Our Ref: 2021930
Date: 30/09/2021
[REDACTED]@portsmouthcc.gov.uk

RE: Comments from Portsmouth City Council as an Interested Party on the responses to the Secretary of State's 2 September 2021 request to the Applicant in respect of Application by AQUIND Limited for an Order granting Development Consent for the AQUIND Interconnector Project.

DRAWING No: EN020022-2.10-EL-Sheet1	REV: 03
--	------------

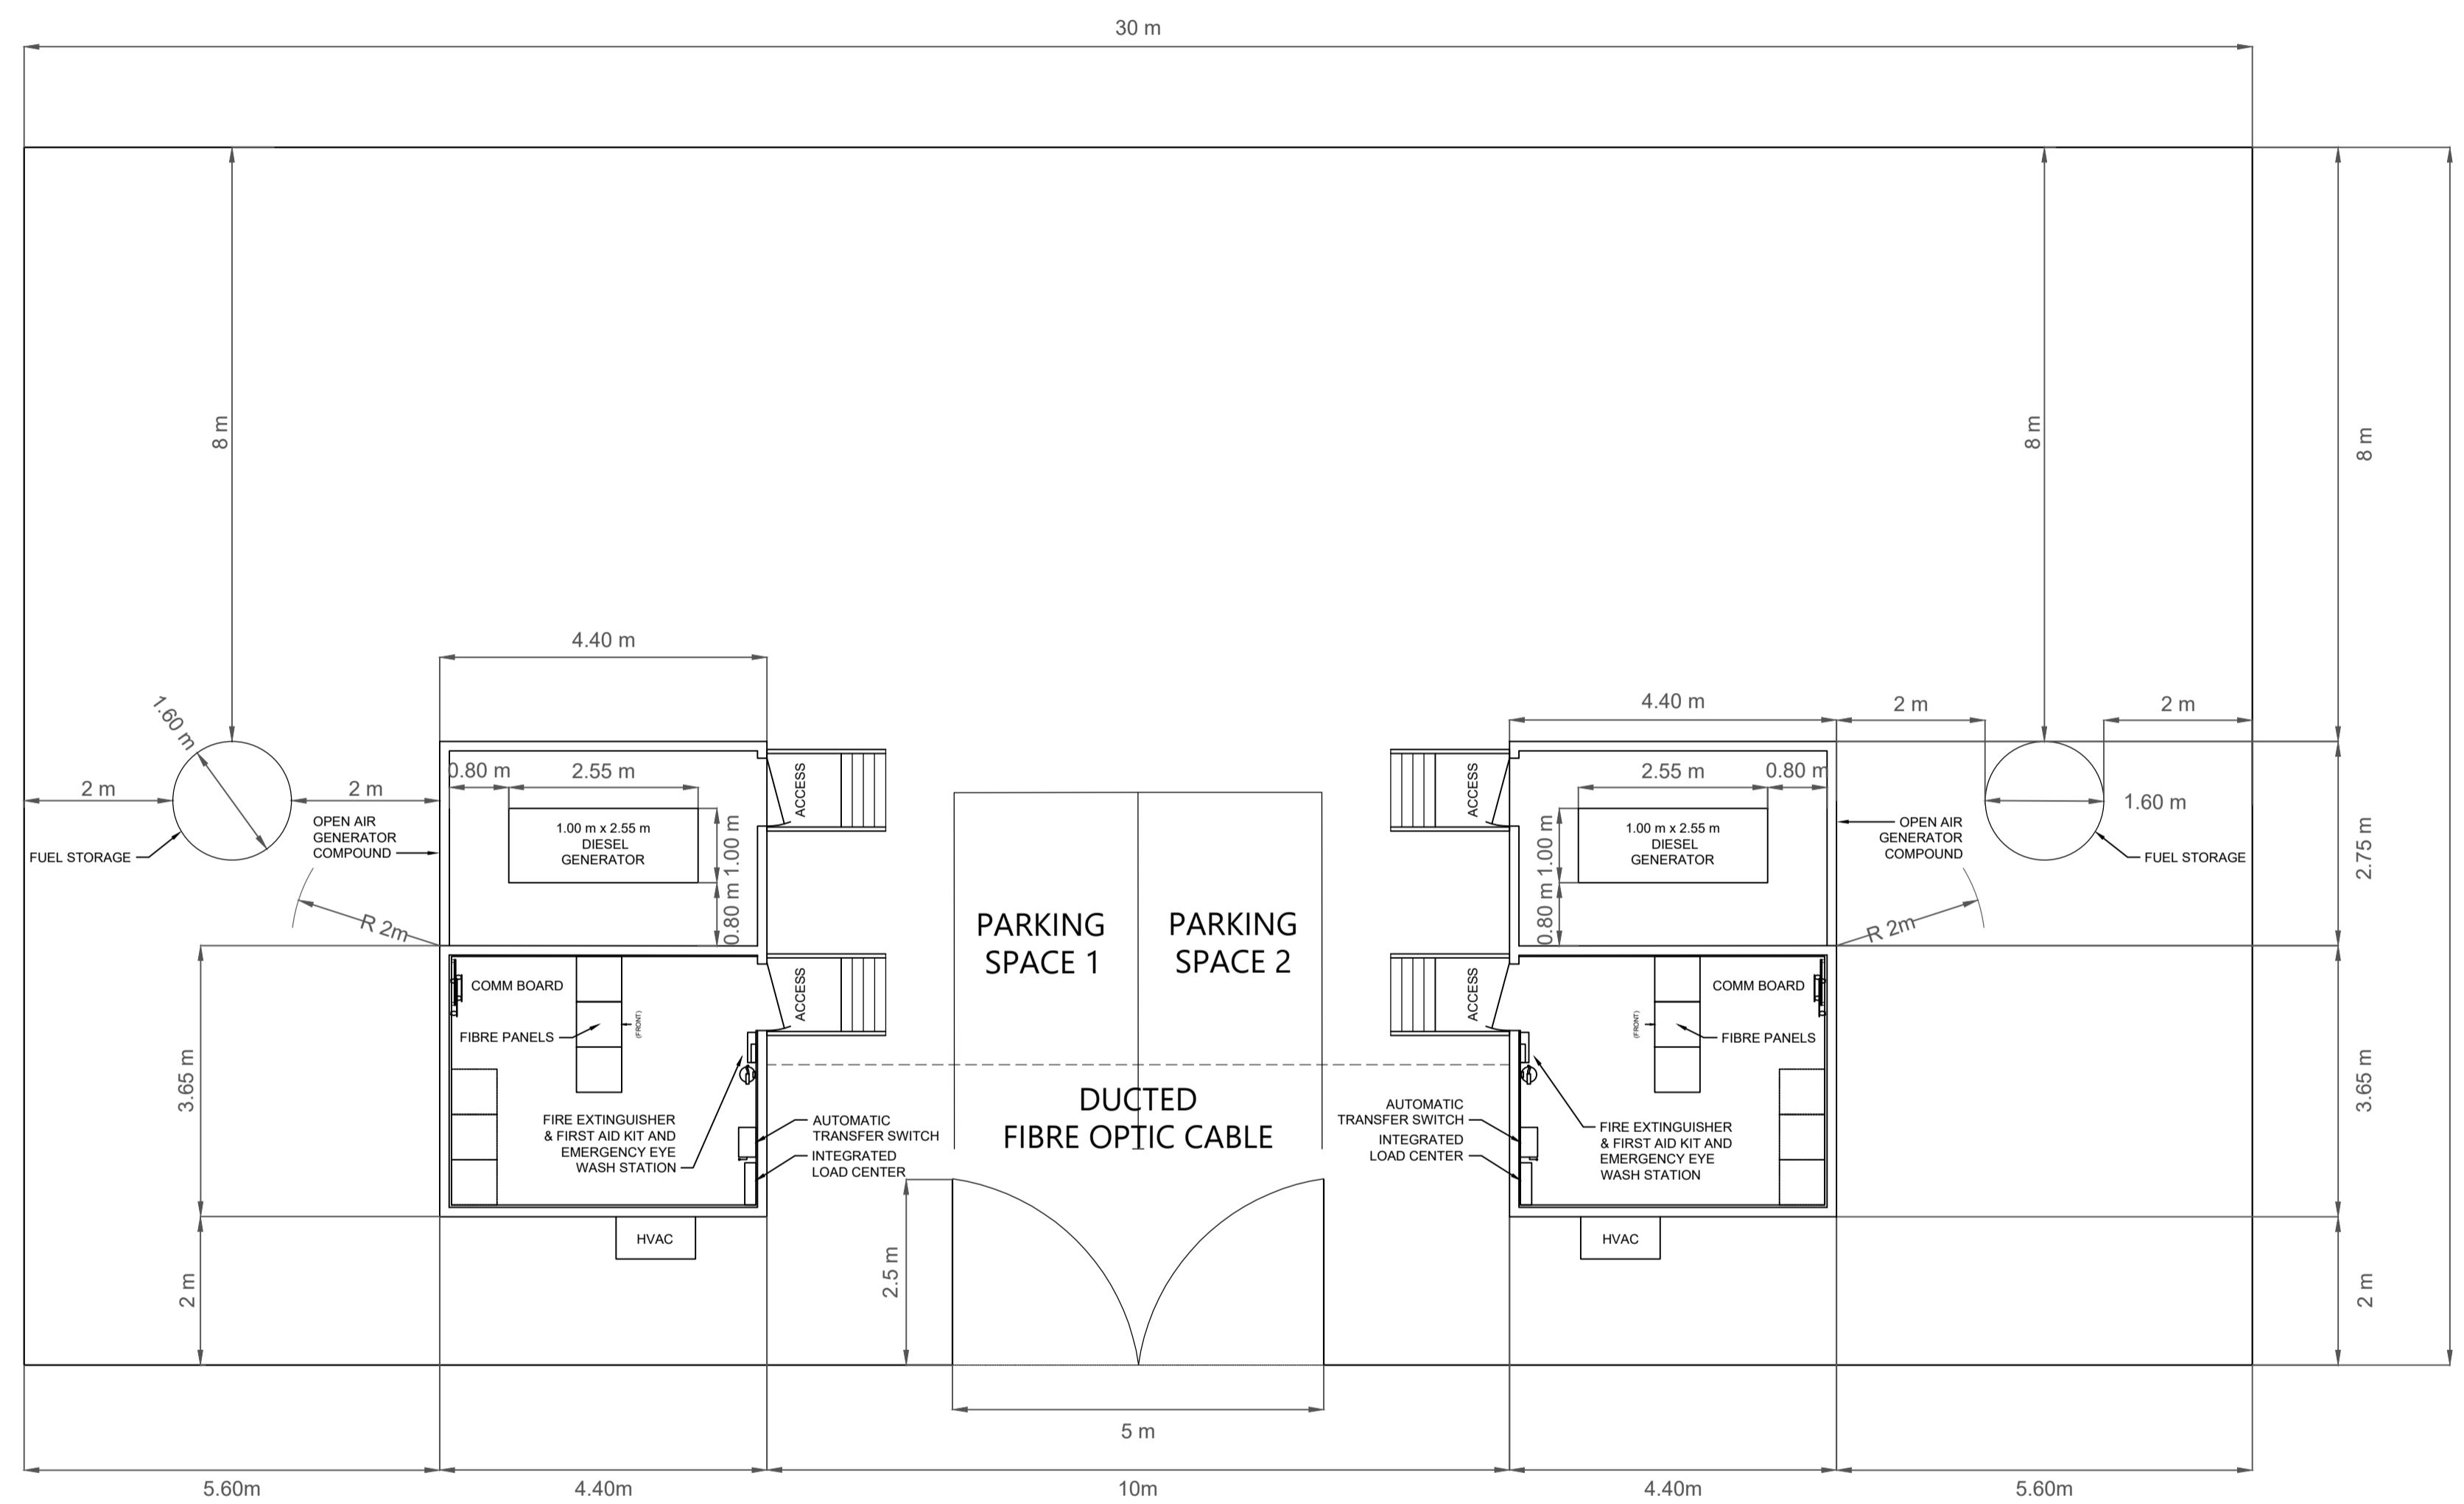
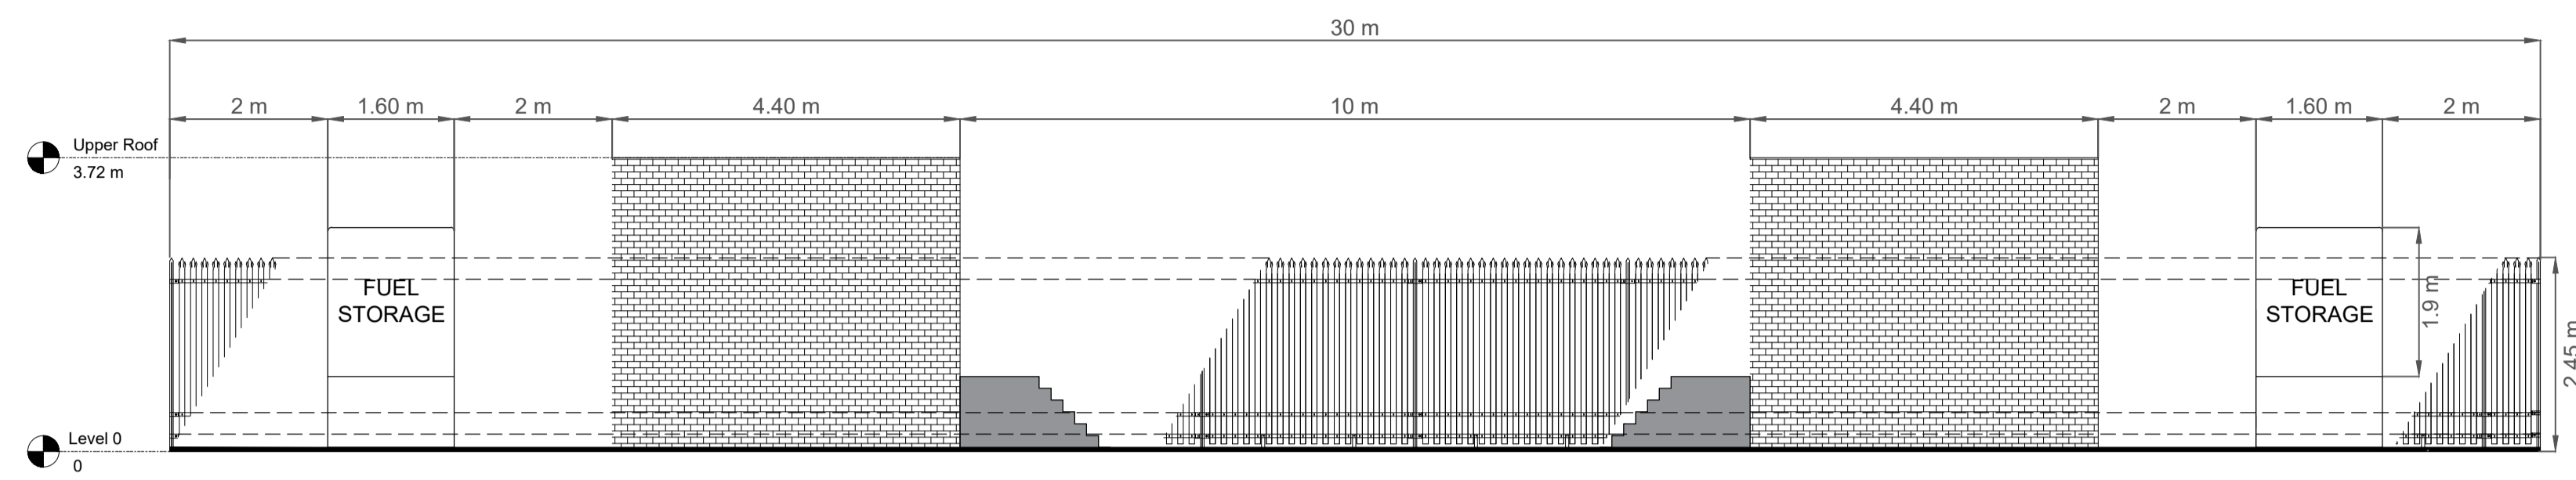
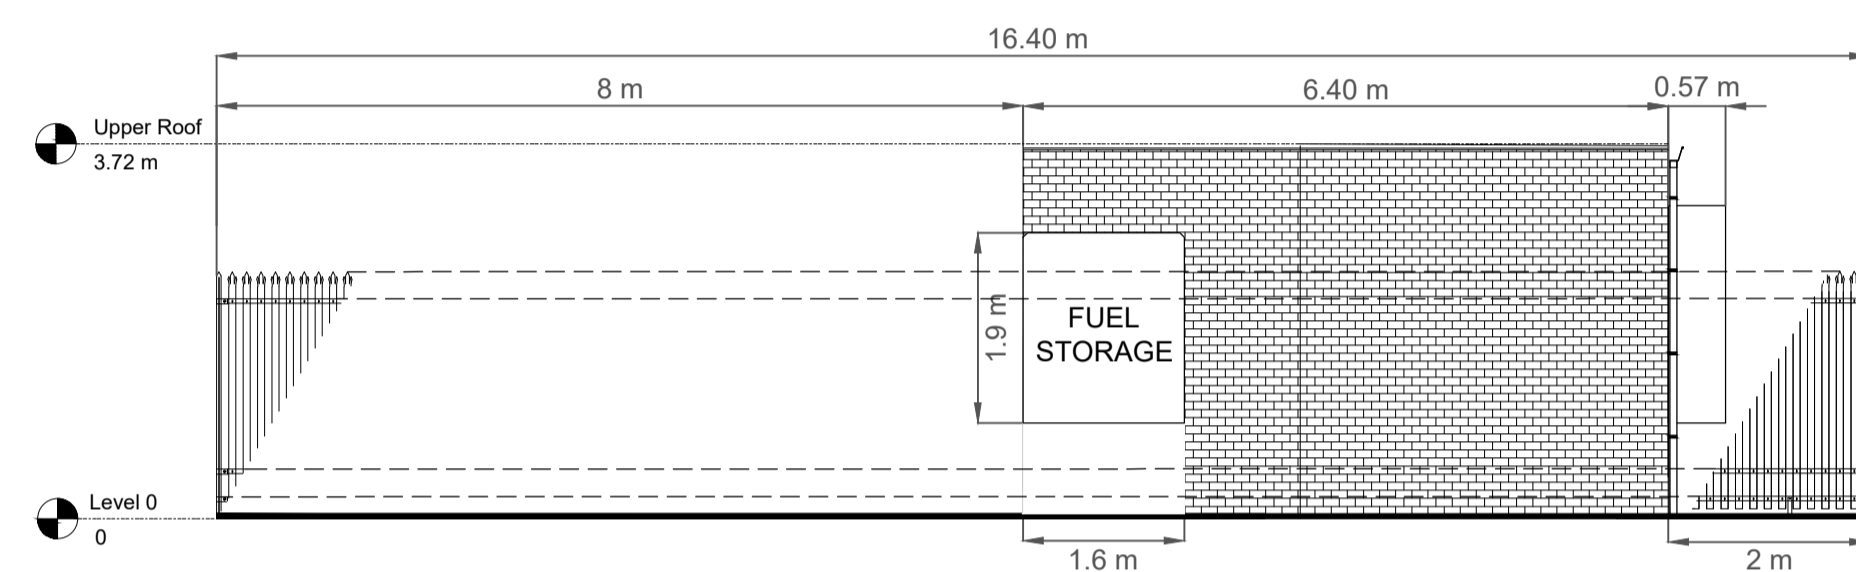
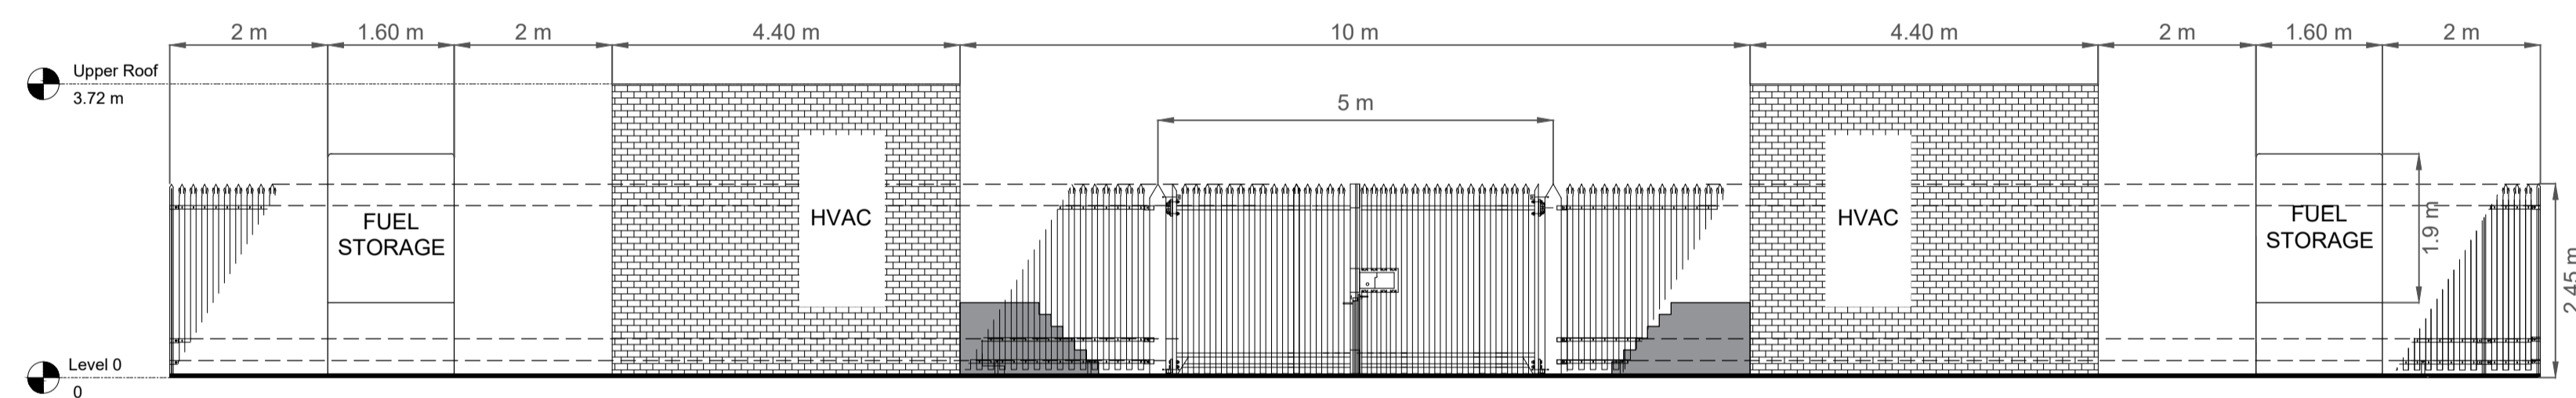
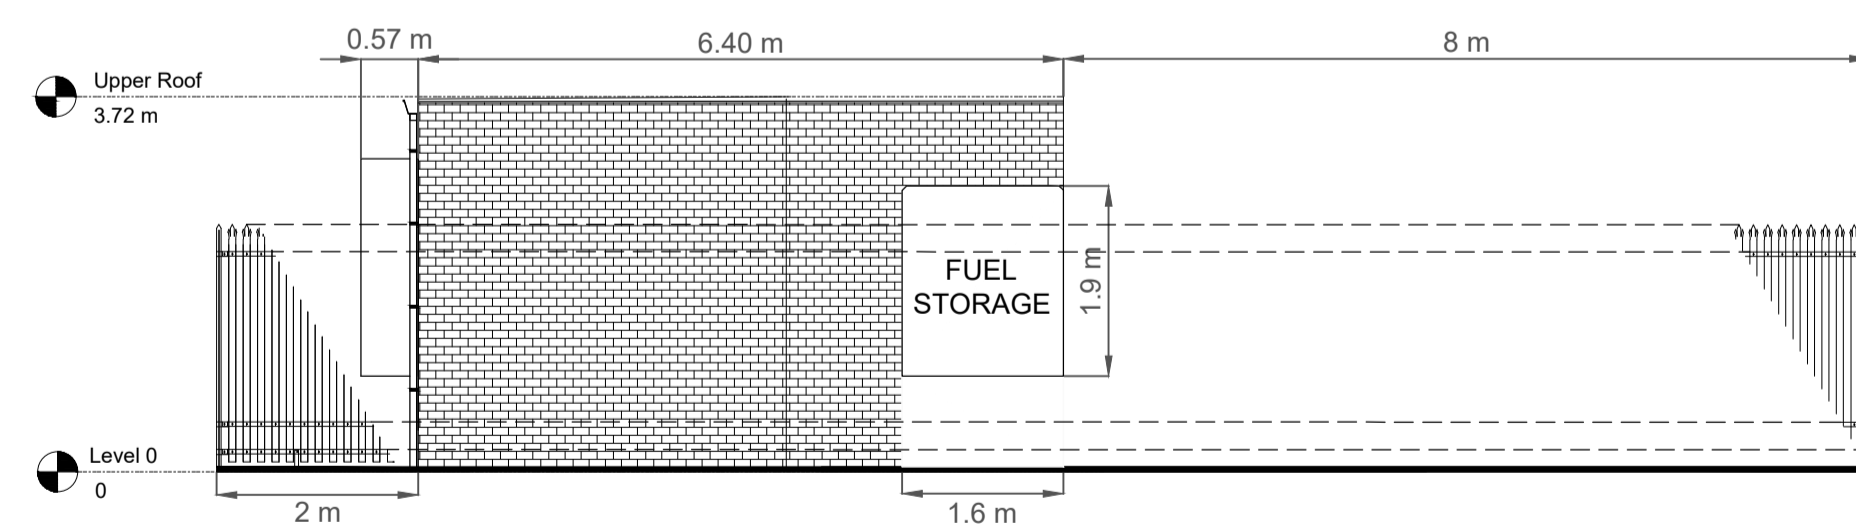
- 1.11 The reasons given by the Applicant for still needing two separate ORS buildings (which in turn lead to the contrivance of an extended area for the non-commercial related ORS) are vague as set out above. In addition the Applicant has not demonstrated that a single ORS building with appropriate internal compartmentalisation for the equipment of each circuit could not be achieved, most especially in light of the acknowledged reduction requirement

of equipment which would otherwise be proposed by 2/3. A single building could obviously reduce land-take and visual impact.

- 1.12 As a clear illustration of the Applicant's attempts to find a way to avoid a reduction in landtake and Order Land the Secretary of State is asked to consider the fact that despite a reduction in plan area of 63.5% to the ORS buildings, as measured from the Applicant's latest drawings submitted with its response of 16 September ("Response to Secretary of State Consultation of 2 September - 2.11 Alternative Optical Regeneration Station(s) Parameter Plan"), the reduction in the ORS compound area and overall permanent land-take has only reduced by a minimal extent.

- 1.13 In light of the foregoing concerns raised in respect of purported basis for 'necessary' separation distances for fuel tanks, Portsmouth City Council also queries why the Applicant has not considered positioning the fuel tanks further south within the compound in light of the reduced ORS building footprints. This would again reduce the overall permanent acquisition of land. This the Applicant should be obliged to do in order to prove that the full extent of land is required and CA is a last resort.

- 1.14 In relation the Applicant's claimed need for an 8-metre separation from the northern fence to the ORS equipment to protect against falling trees or rather a single tree, PCC would reiterate that the Applicant was clearly content with a 2-metre separation distance in its earlier representation at response Ref: REP1-008. In addition the Council considers that, if it truly is a threat, the Applicant could have designed its scheme to place the ORS further from the single established Ash tree.
